Application Ref:	3/2025/0630			 Ribble Valley Borough Council www.ribblevalley.gov.uk
Date Inspected:	N/A	Site Notice:	N/A	
Officer:	LW			
DELEGATED ITEM FILE REPORT:				APPROVAL

Development Description:	Certificate of Lawfulness for proposed loft conversion and rear dormer.
Site Address/Location:	1 Pasture Grove, Whalley, BB7 9SJ.

4 ROOF PLAN
1 : 50

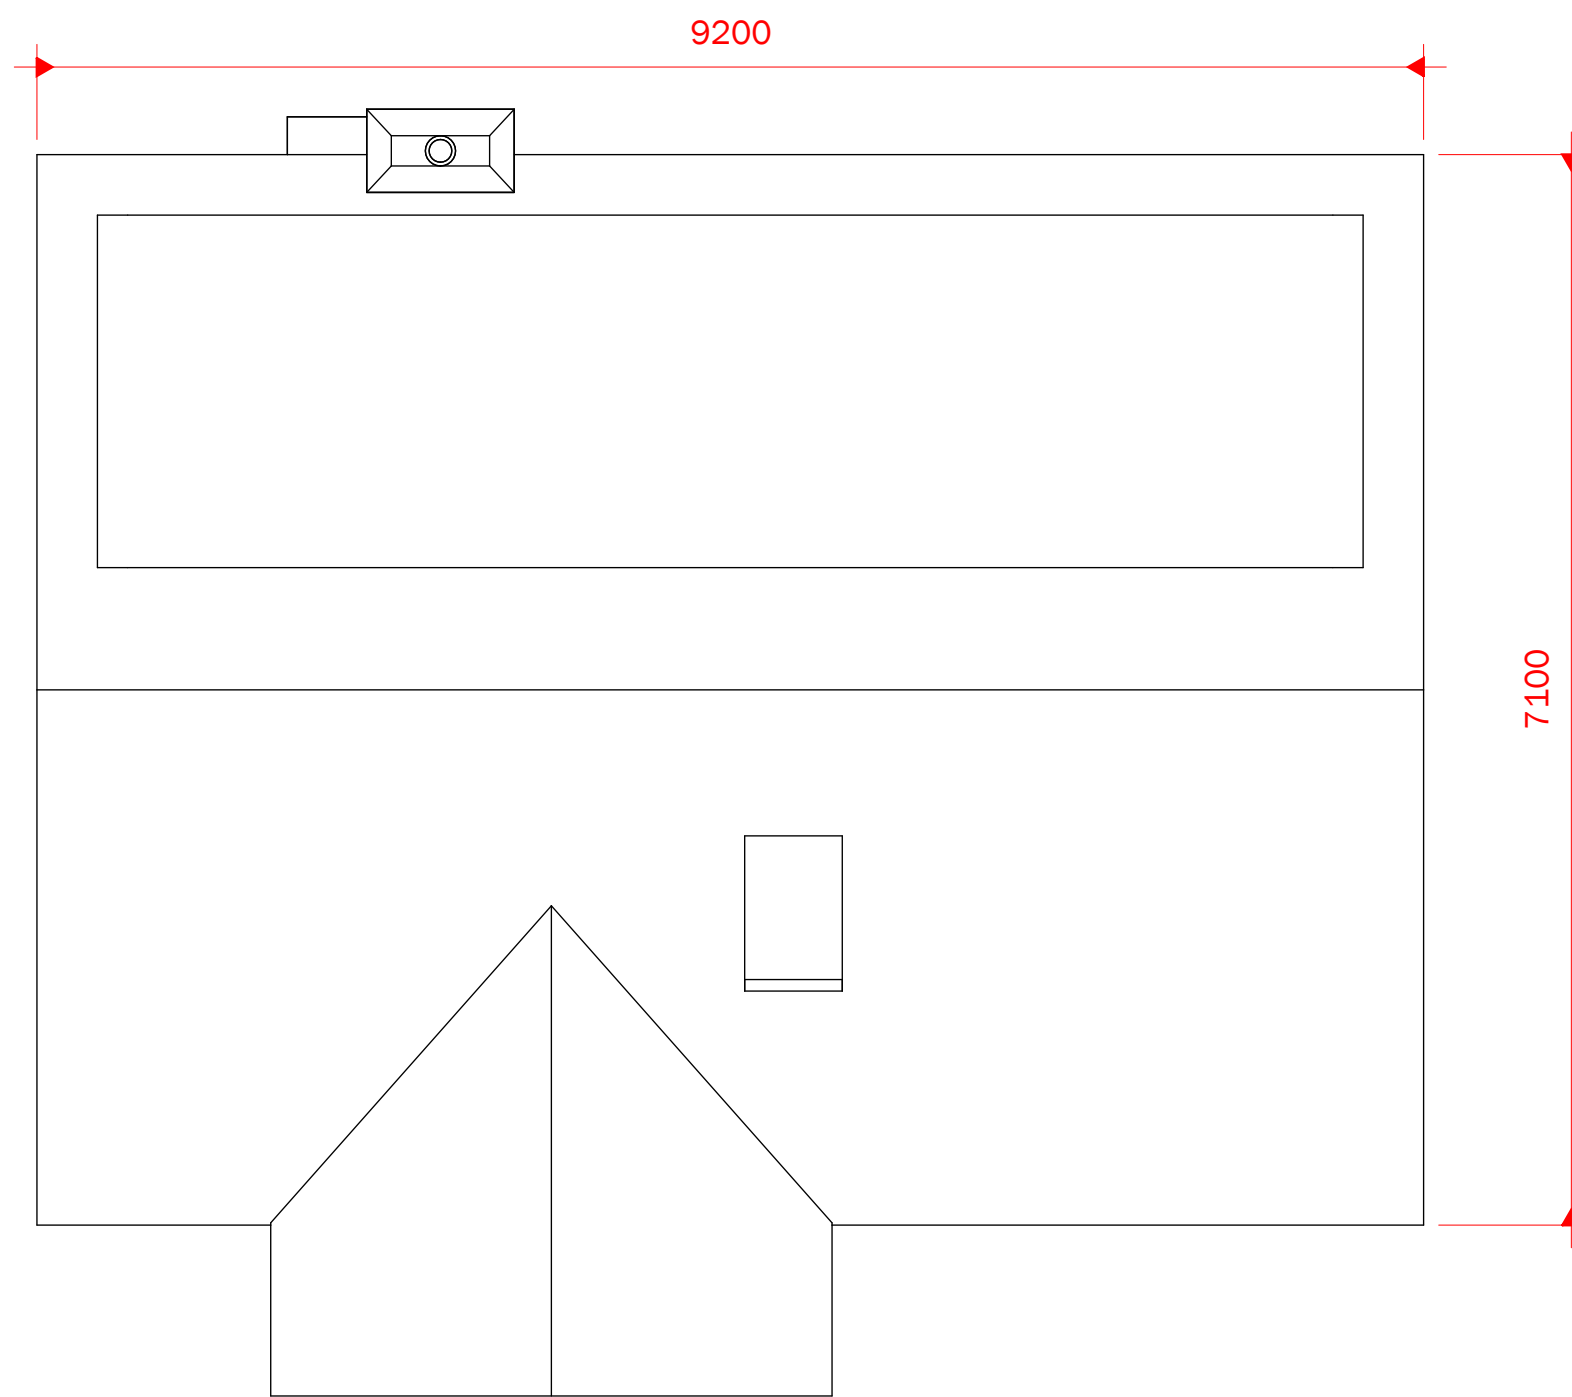
The proposed dormer would project 2.3m from the roof slope of the application dwellinghouse, with a length and height of 8.4m and 2.5m respectively.

The proposed development would not exceed the height of the highest part of the existing dwellinghouse.

The proposed dormer would not extend beyond the plane of any roof slope which forms a principal elevation of the dwellinghouse and fronts a highway.

The eaves of the original roof are to be maintained, and the proposed dormer would not be less than 0.2 metres from the eaves. The dormer would also not extend beyond the outside face of any external wall of the original dwellinghouse.

PROPOSED SECTIONS

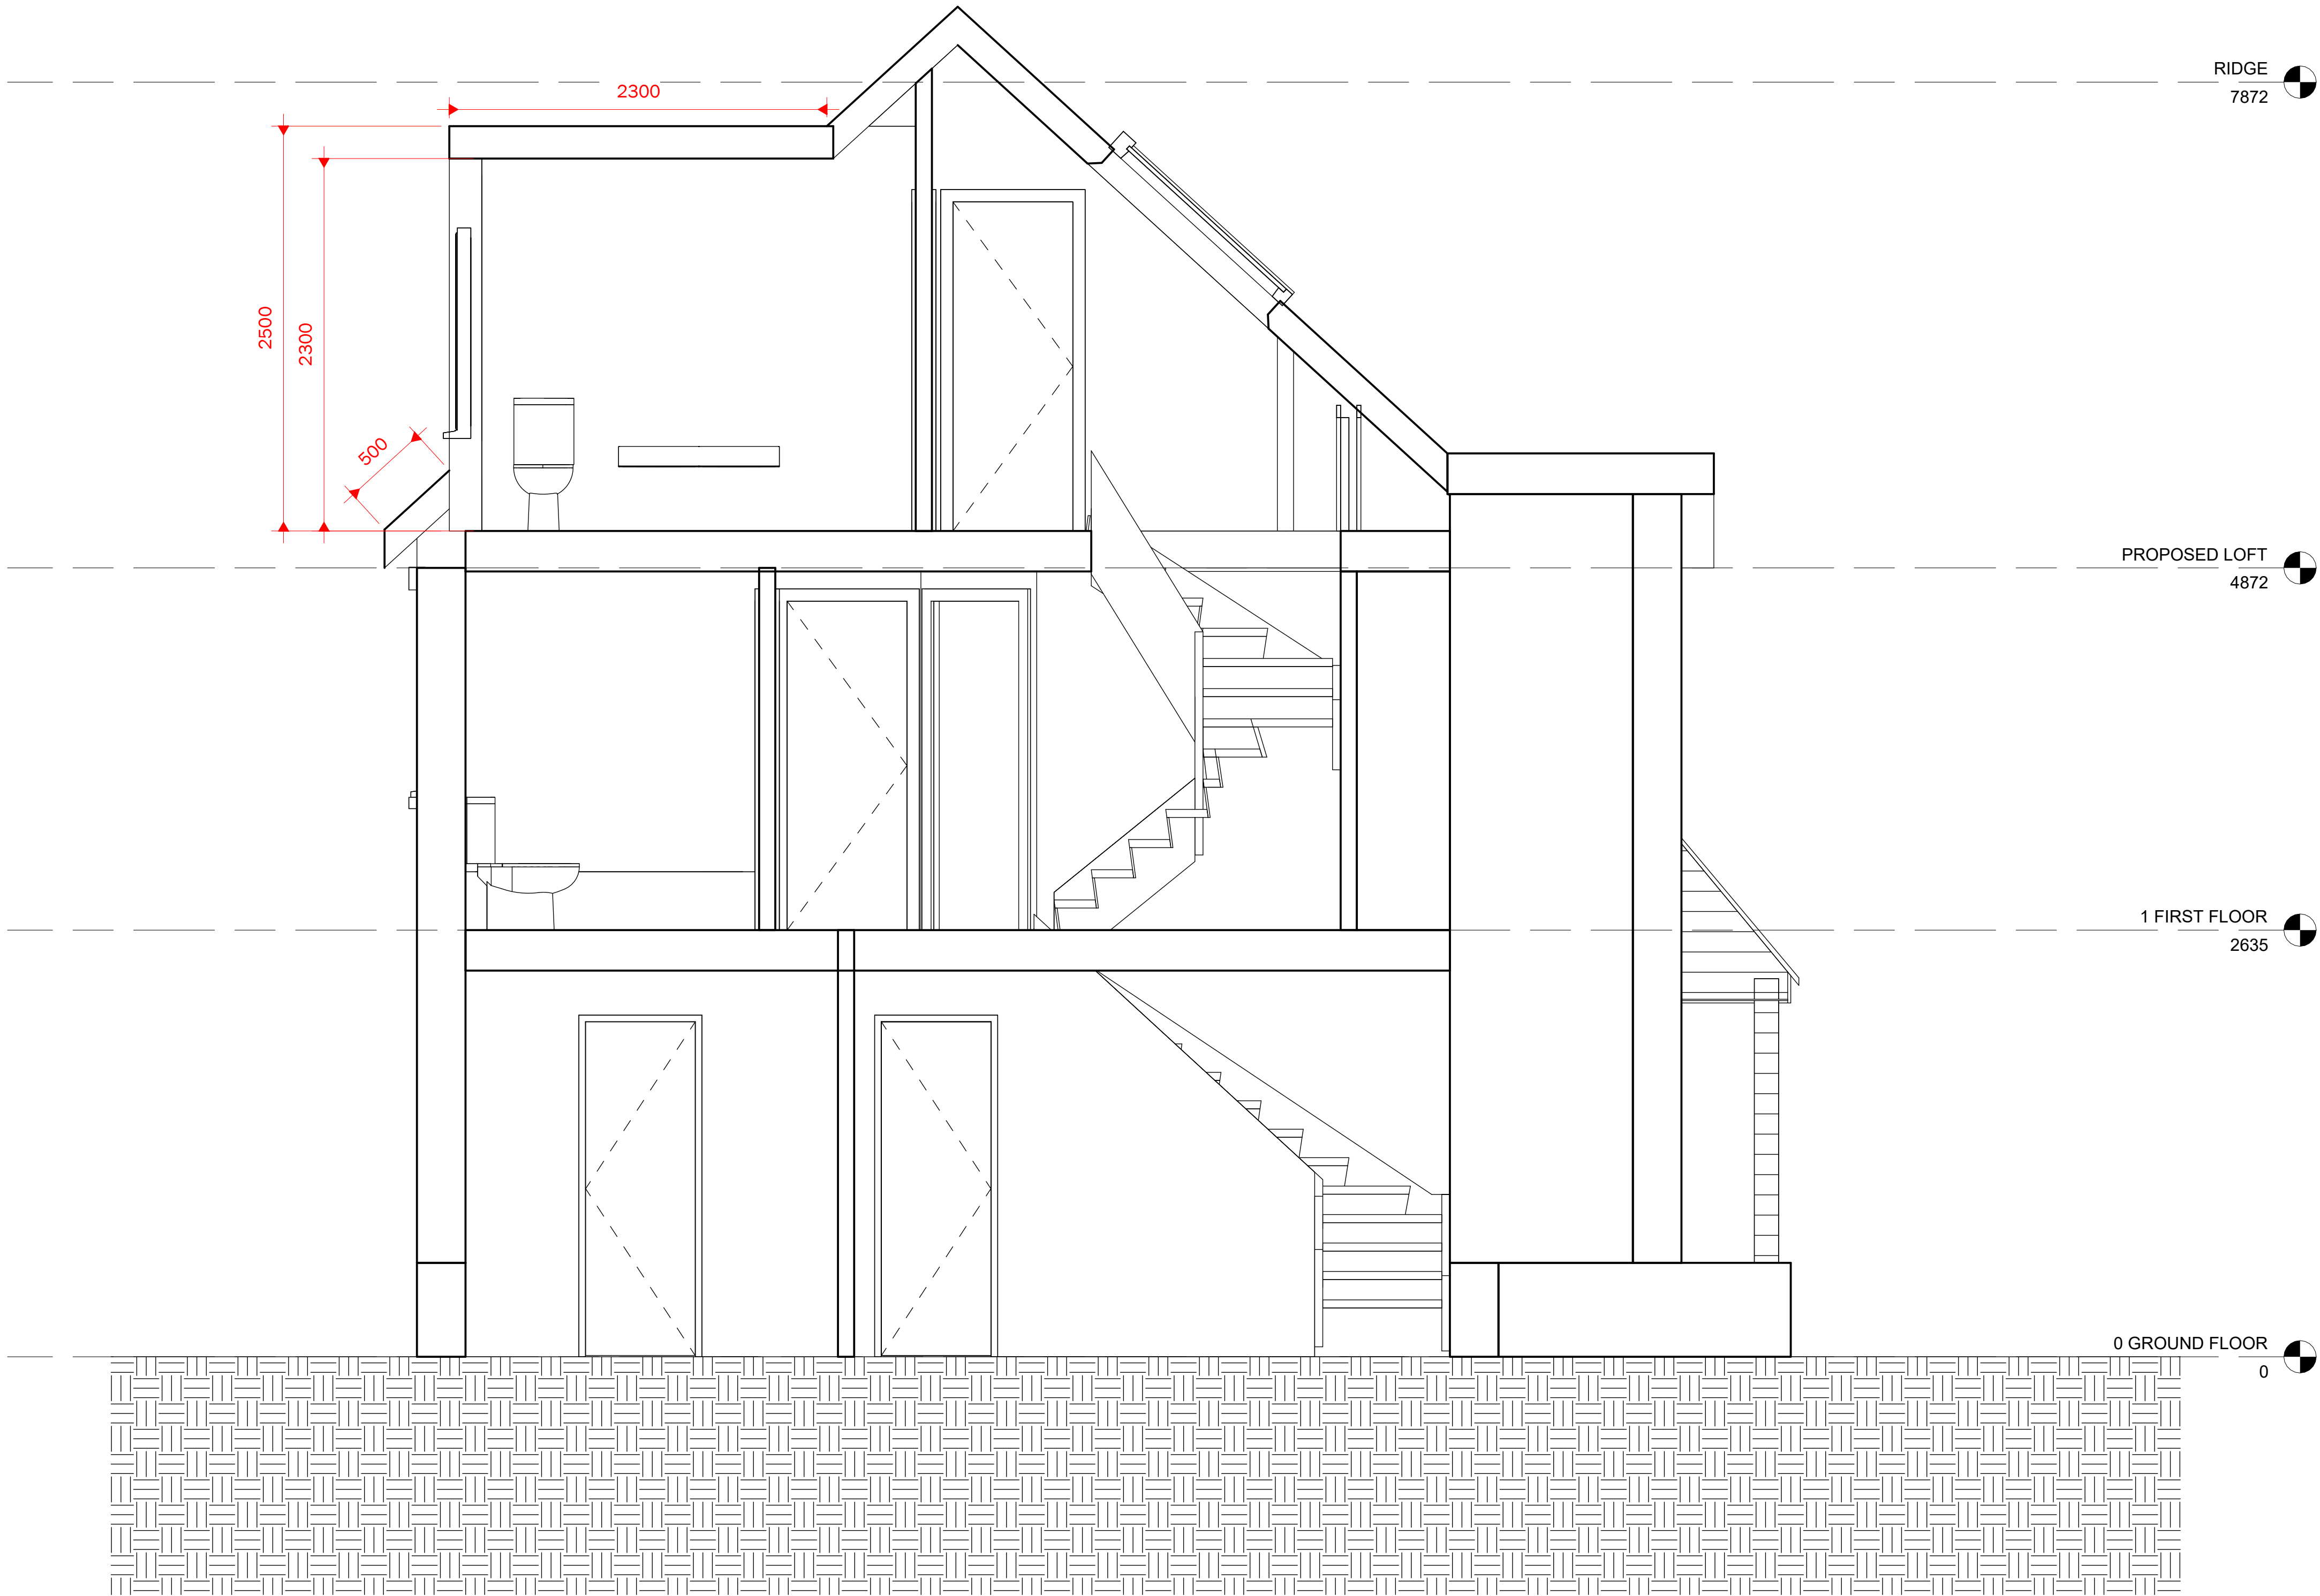
The application property is a detached dwelling, and the proposed dormer would increase the cubic content of the original roof space by approximately 24.2 cubic metres. The development would therefore comply with the above.
